Our reference: DOC16/206758  
Contact: Alexander Spaller

### **SSD 6820 Light Weight Aggregate Facility – RTS – Additional Air Quality Information**

The Environment Protection Authority (EPA) has reviewed the Proponent's additional information submitted as an addendum to the original Response to Submissions (RTS), in conjunction with the revised Air Quality Impact Assessment (AQIA) prepared by Airlabs Environmental Pty Ltd dated 31 March 2016.

Figure 4: A typical layout of a Cascade Scrubber System to be installed at Plant 2

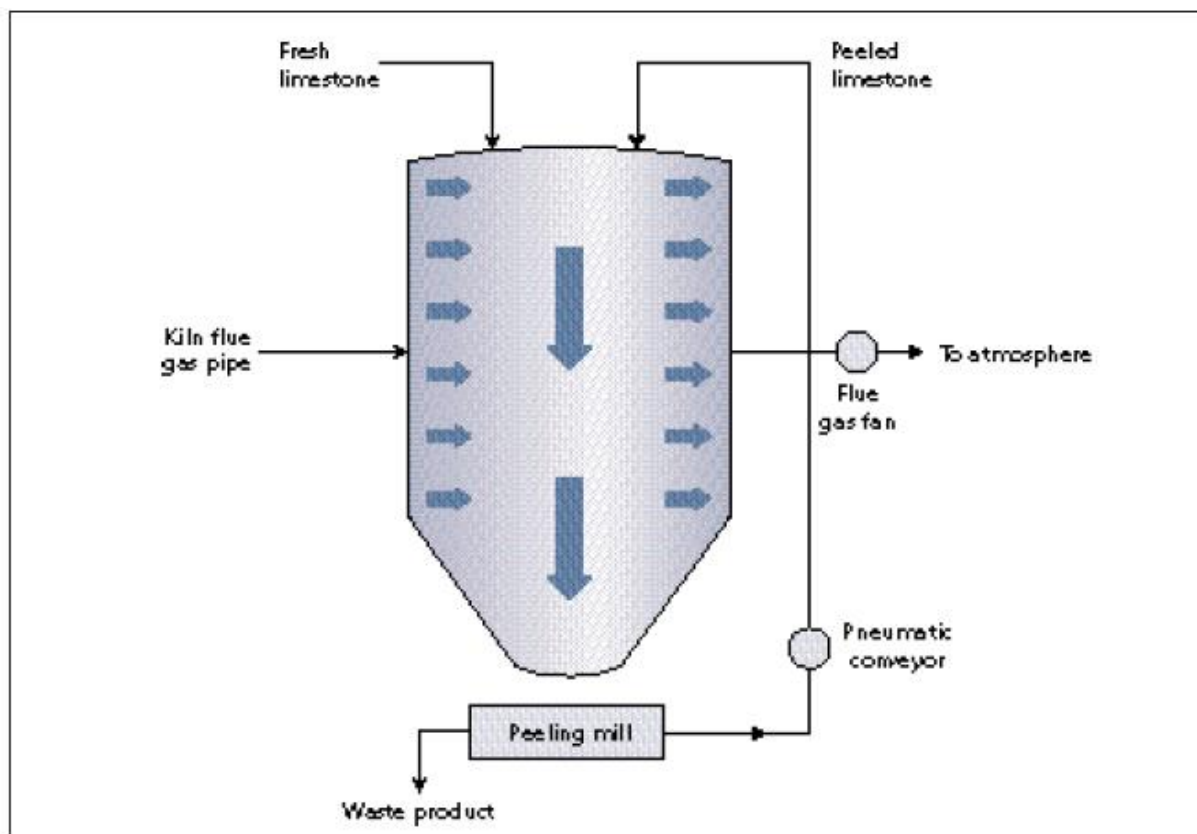
The EPA notes that Brickworks has agreed to install a Cascade Scrubber system for Plant 2 to reduce Hydrogen Fluoride (HF) emissions, which would be installed on the existing Plant 2 operations prior to undertaking construction and operation works for the Stage 1 LWA Project.

Figure 7: Positioning of the Ammonium Hydroxide Injection Nozzles in the RTO Combustion Chamber

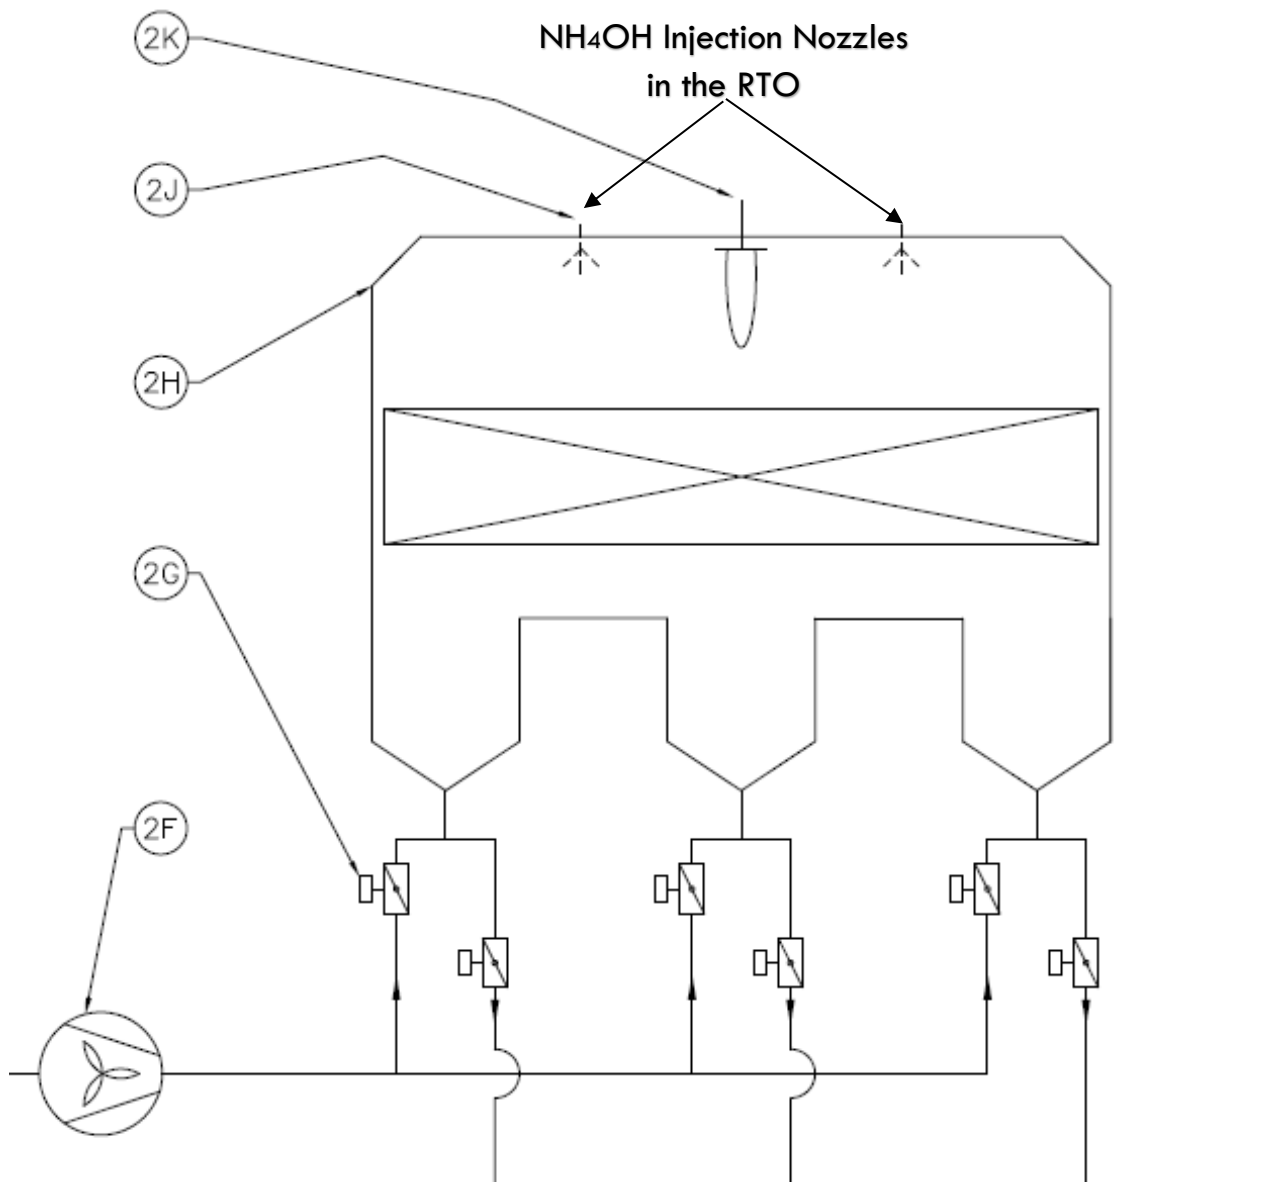
- Clarify the Selective Non-Catalytic Reduction (SNCR) component of the proposed emission controls;
- Outline any control efficiencies and emissions associated with the SNCR component of the regenerative thermal oxidiser (RTO), specifically for NO<sub>x</sub> and ammonia;
- Include an assessment of ammonia discharges from the process;
- Clarify that the assessment has adequately considered emissions from fuel used for all operations (including the RTO); and
- Revise the AQIA where required, to address the comments above.

- The US EPA Air Pollution Control Technology Fact Sheet for SNCR states that:
  - For SNCR applied in conjunction with combustion controls, such as low NO<sub>x</sub> burners, reductions of 65% to 75% can be achieved.
  - In the US, permitted ammonia slip levels are typically 2 to 10 ppm.
- Ammonia may contribute to secondary aerosol formation and must be minimised to the maximum extent practical.

*The EPA recommends that the proponent be requested to provide additional information to demonstrate that the proposal can achieve emission performances for NO<sub>x</sub> and ammonia that are associated with proper and efficient operation and good environmental performance of the emission controls proposed.*
